Tel: 01903 737756
Email: planning@arun.gov.uk
www.arun.gov.uk/planning
Please ask for: Laura Mills
Email: laura.mills@arun.gov.uk
Telephone: 01903737794
Our Ref: EP/55/26/HH
Your Ref:
Date: 5th June 2026

Application for Planning Permission for Works or Extension to a Dwelling

Development: Replacement of first floor rear glazing.
Location: Vista Point 21 Tamarisk Way East Preston BN16 2TE

DRAWING No.
2105 3SC03.3

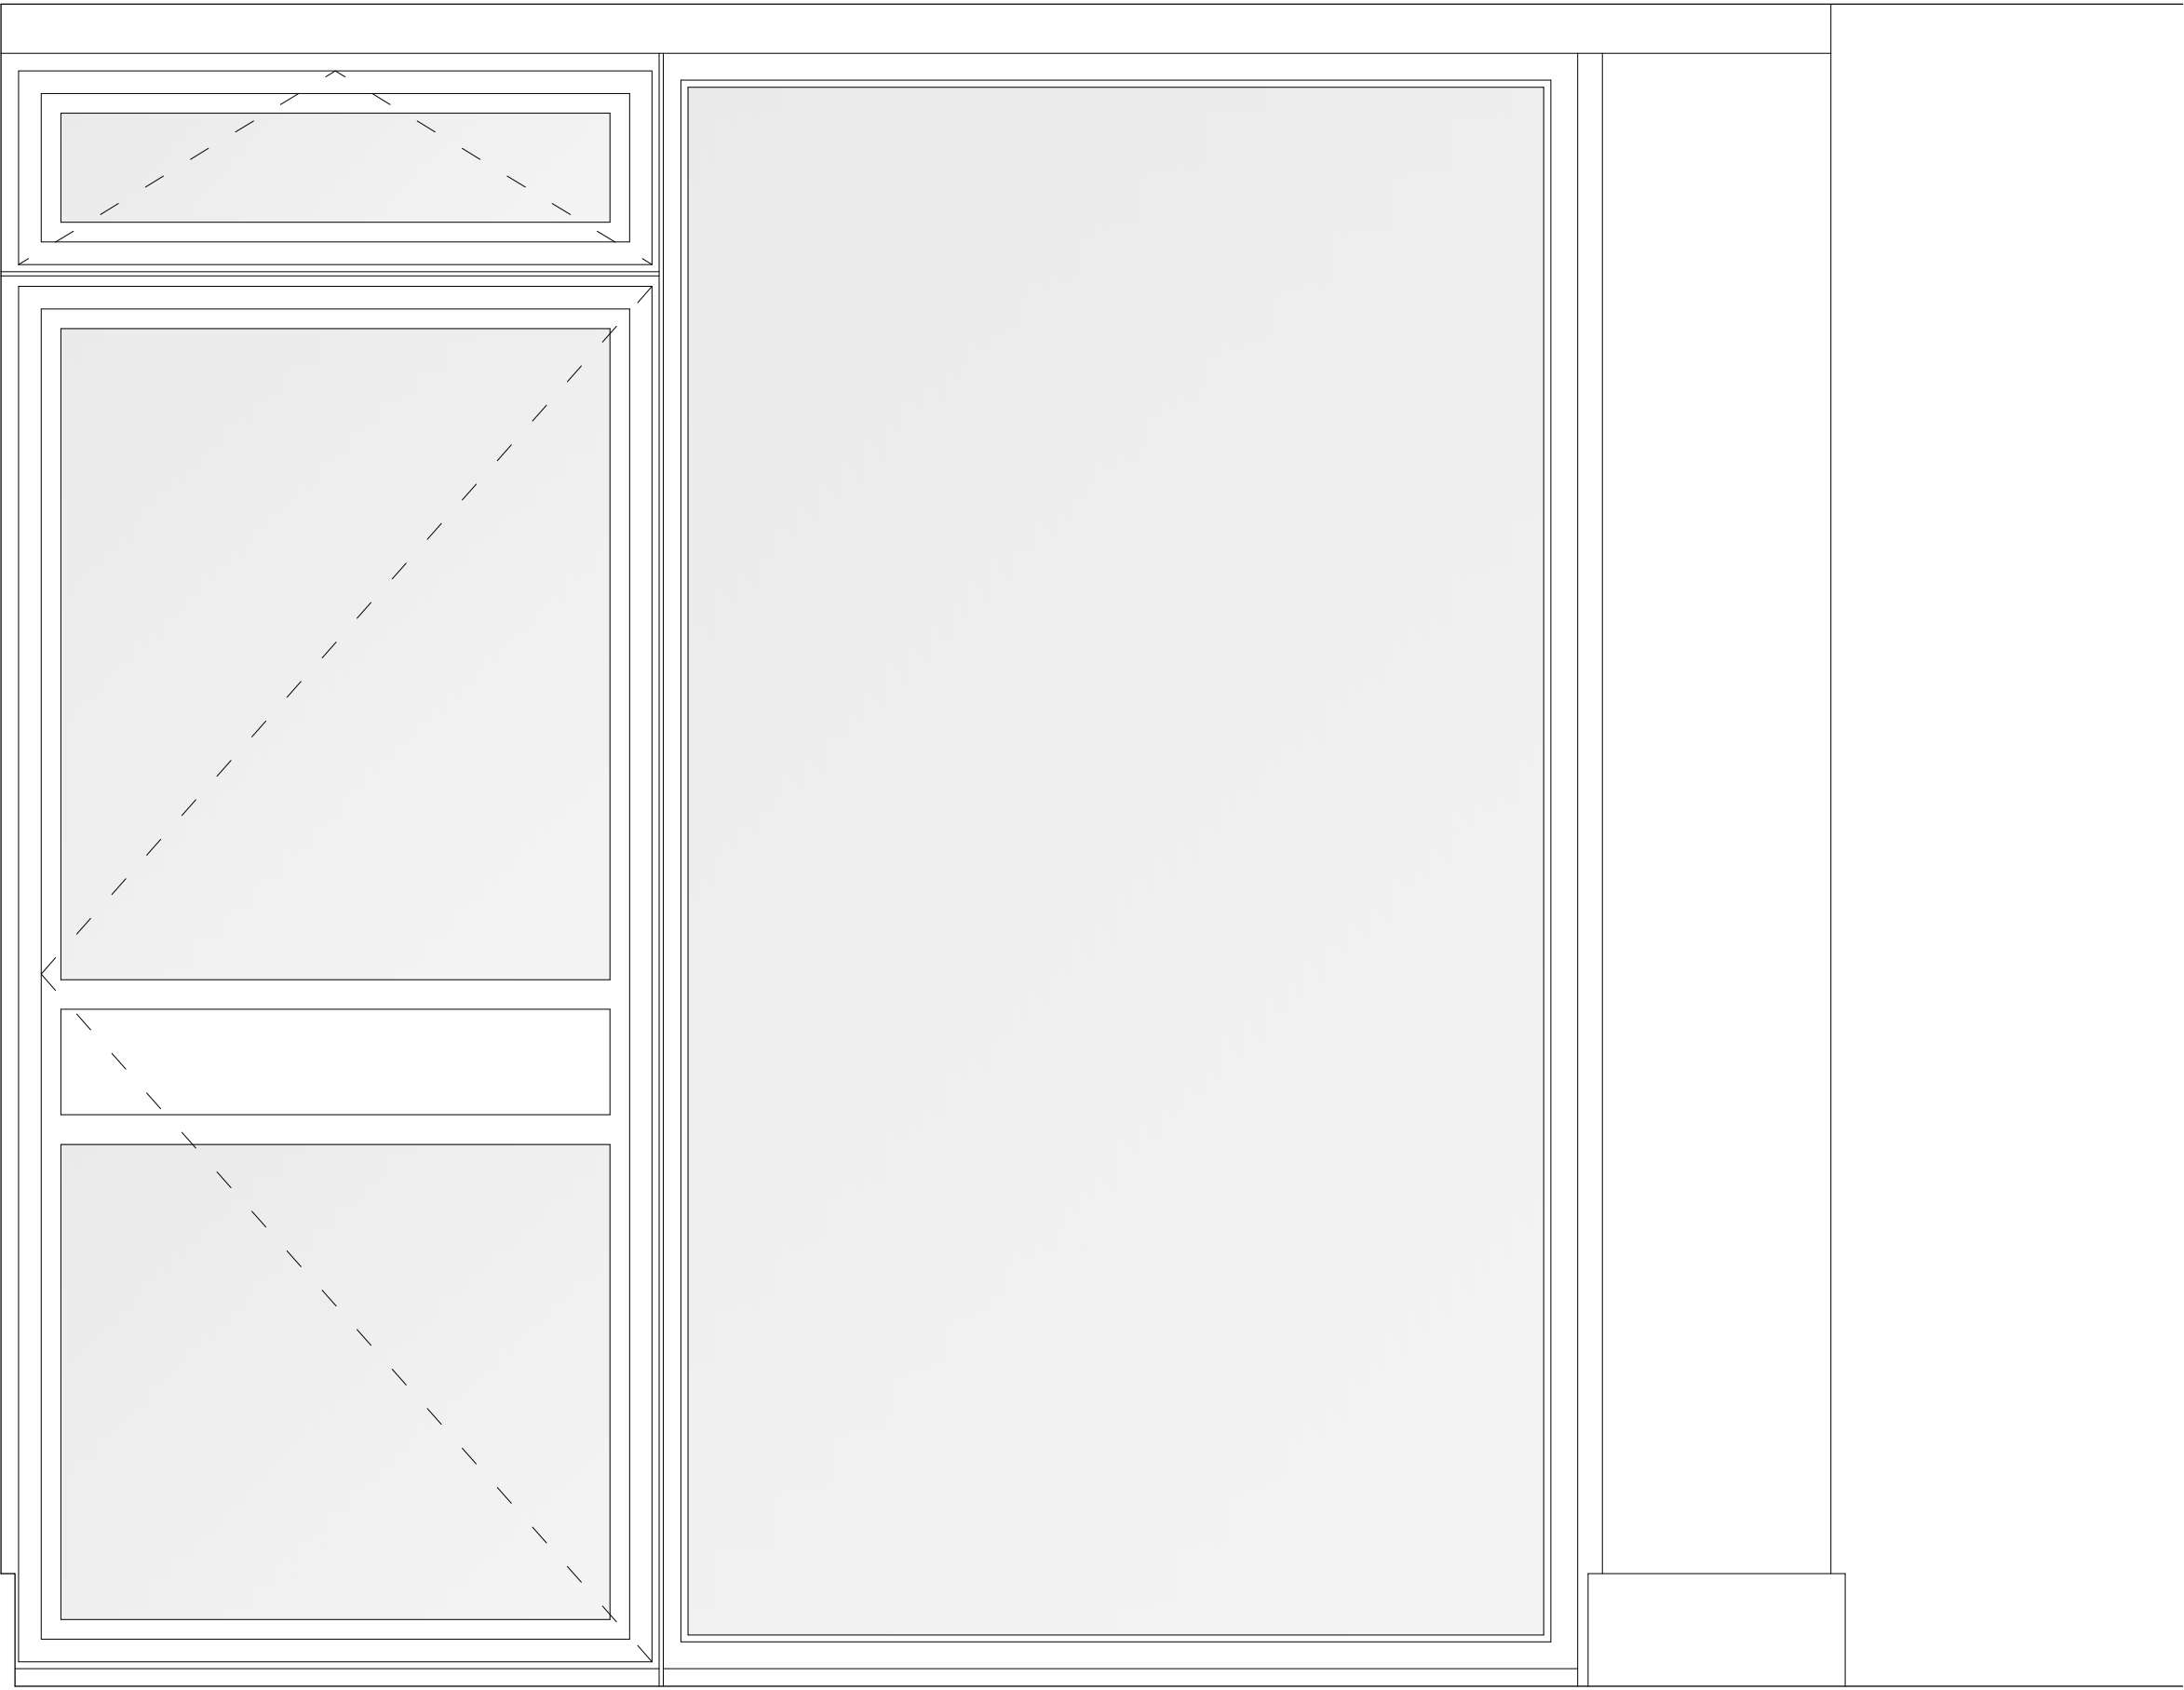
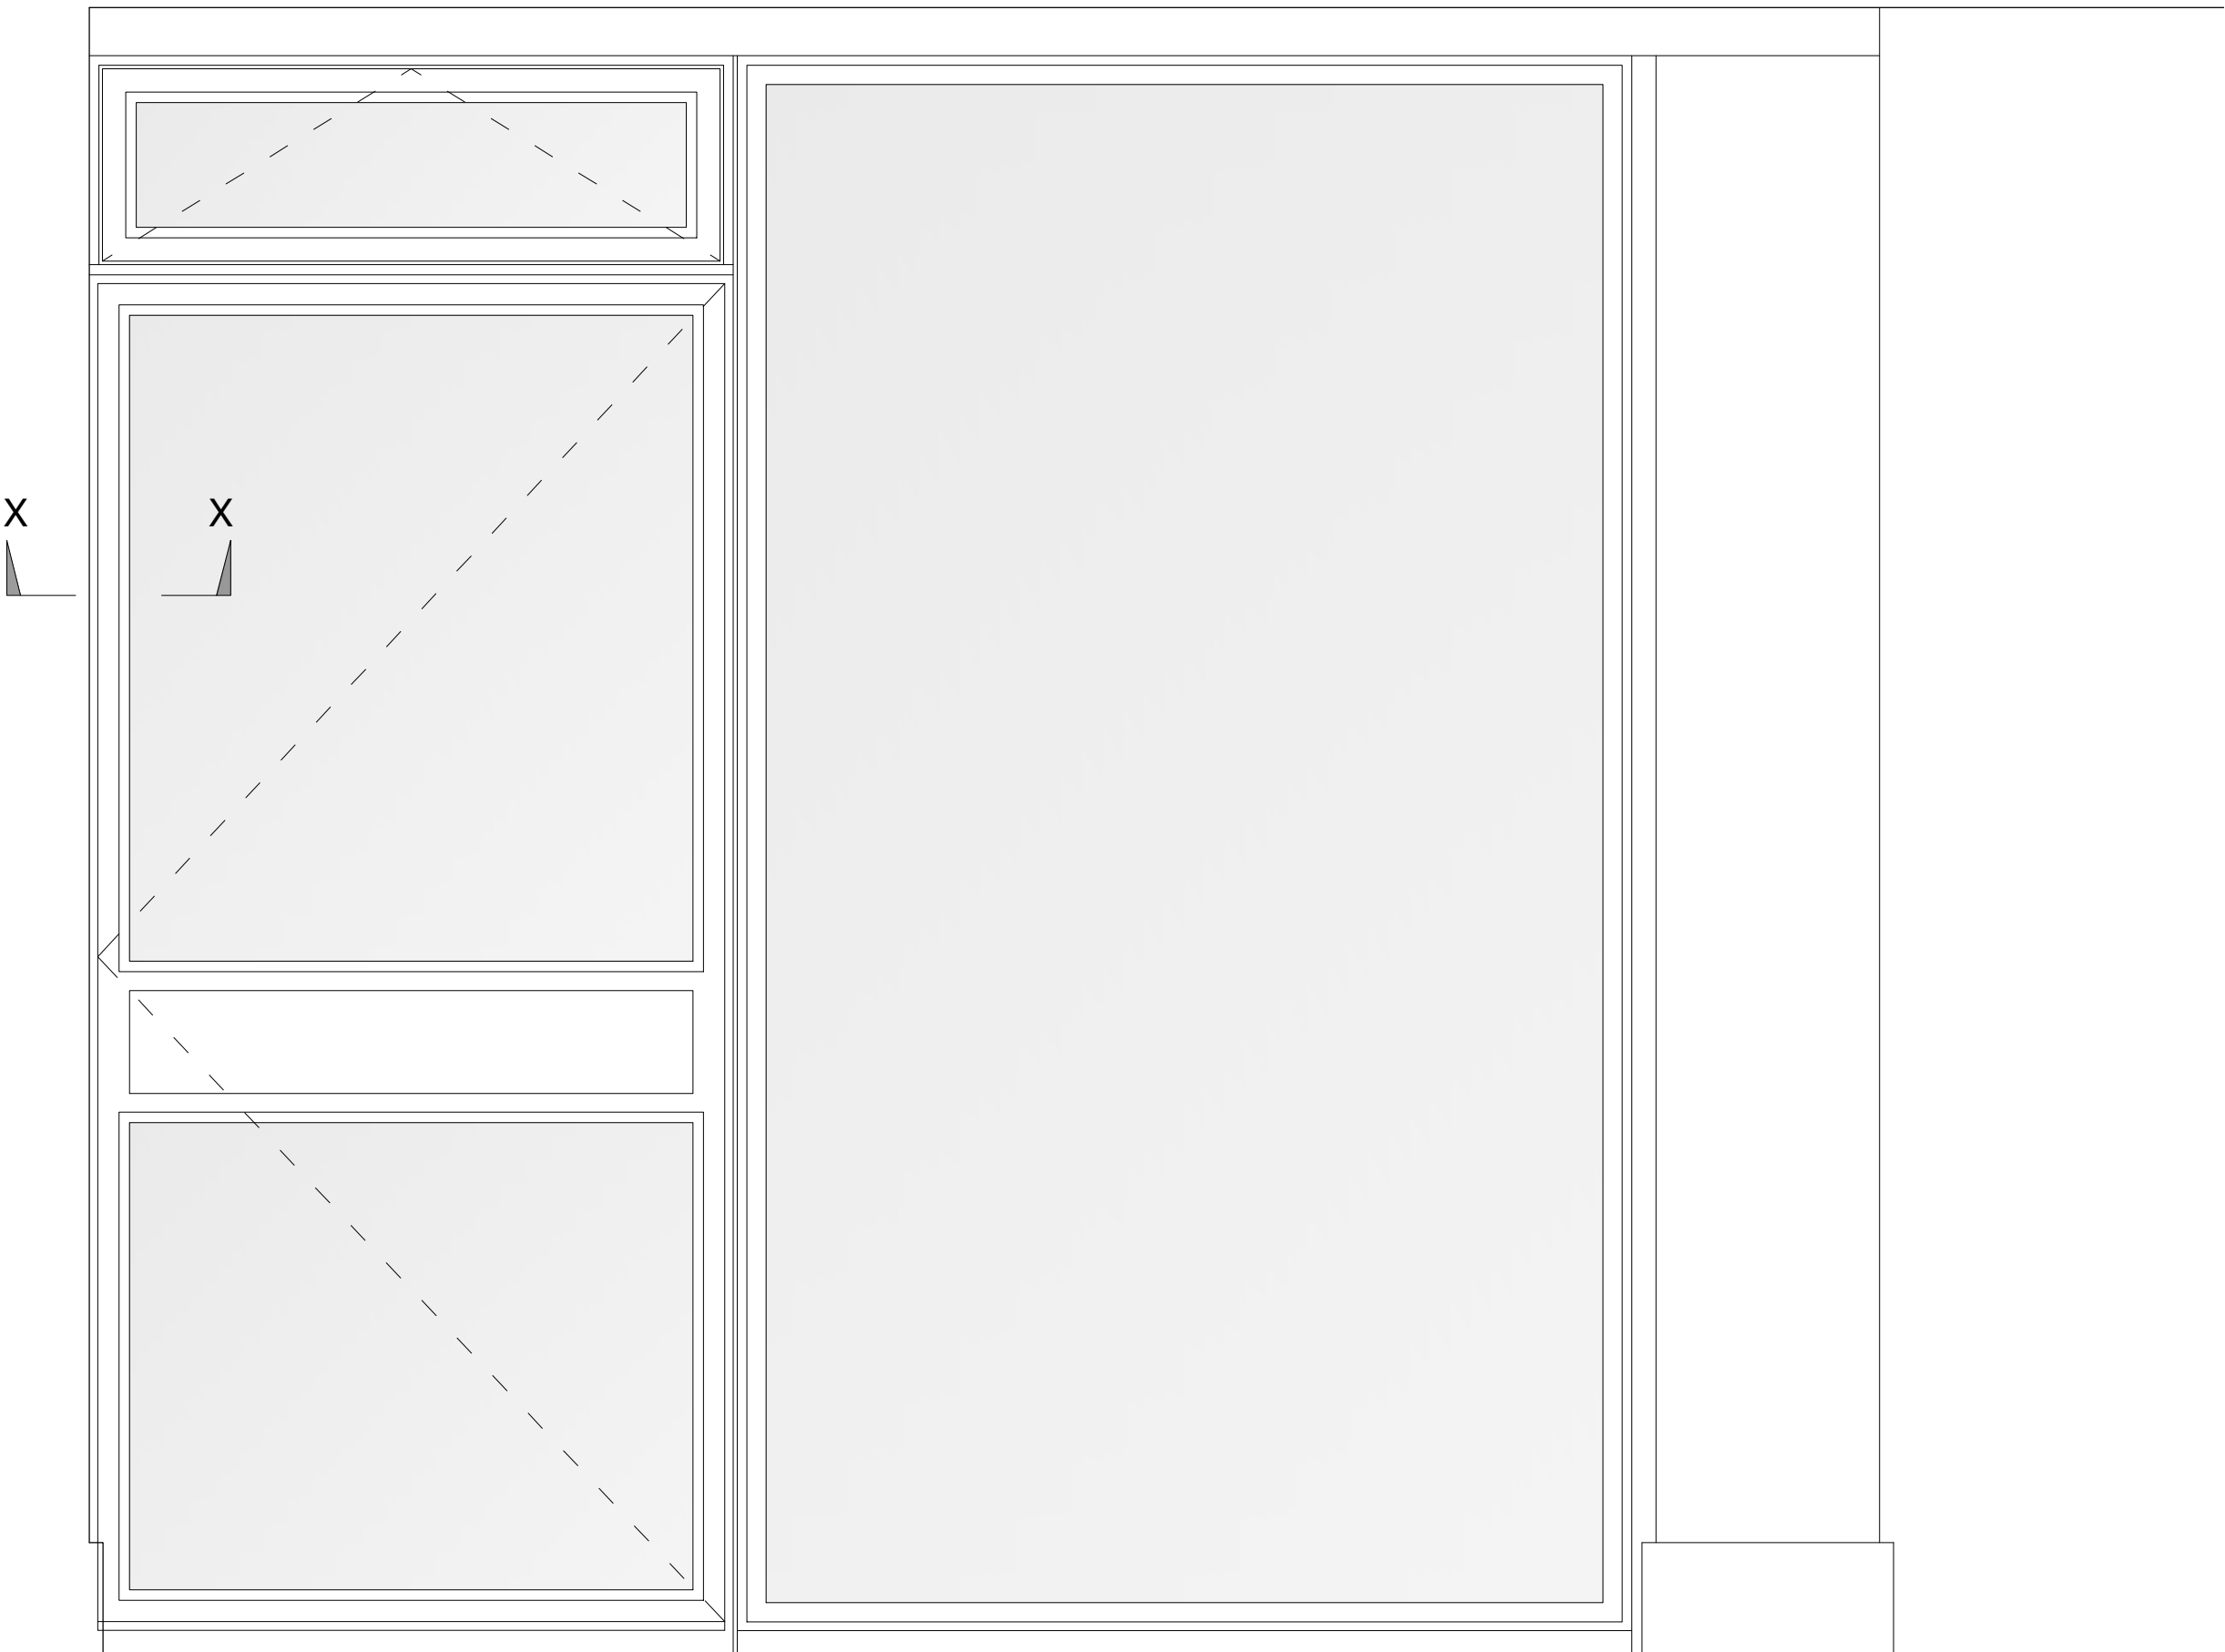
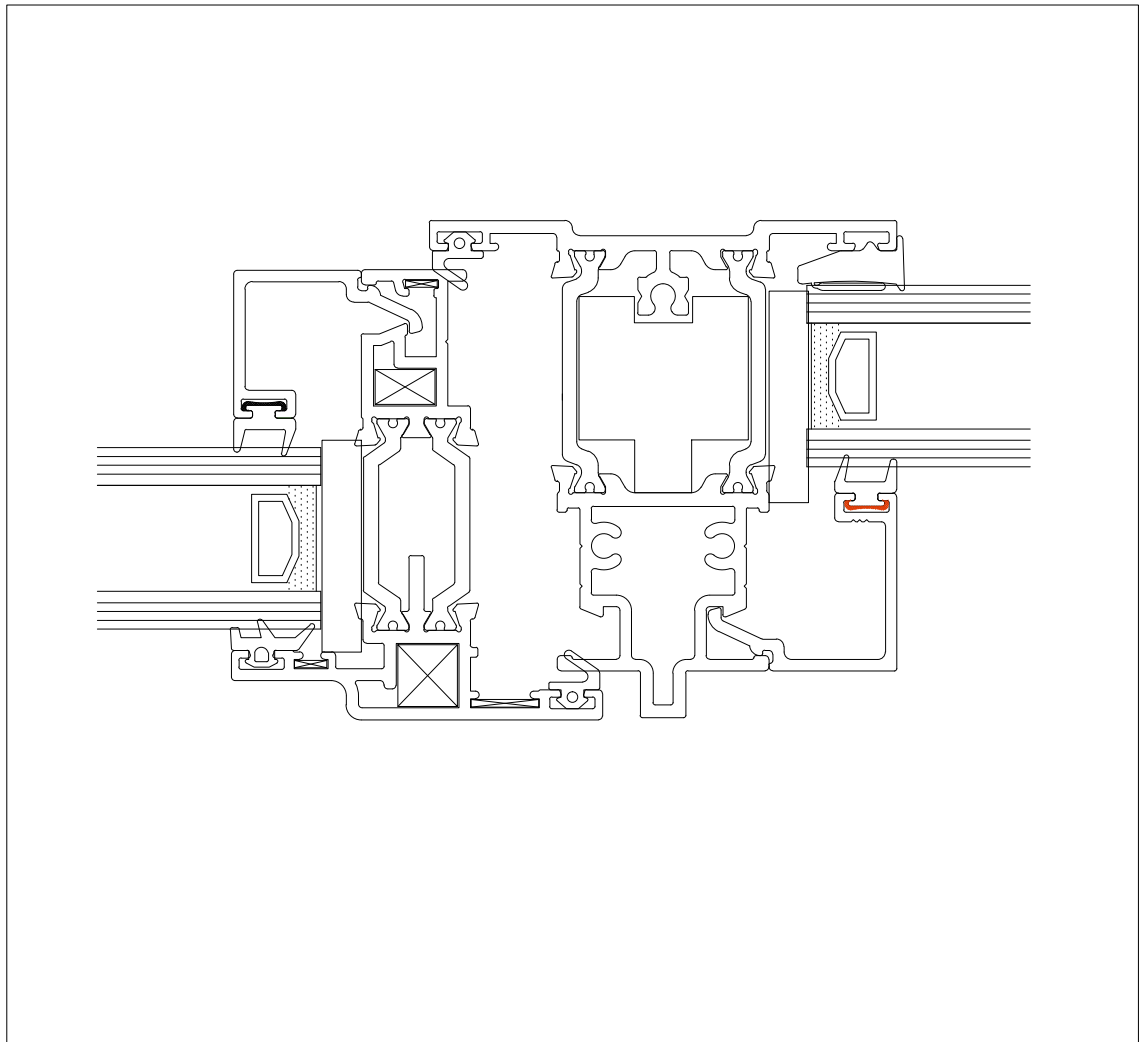
The scale bar does not scale at 1:10 and the plans should be provided to a scale of not less than 1:20.
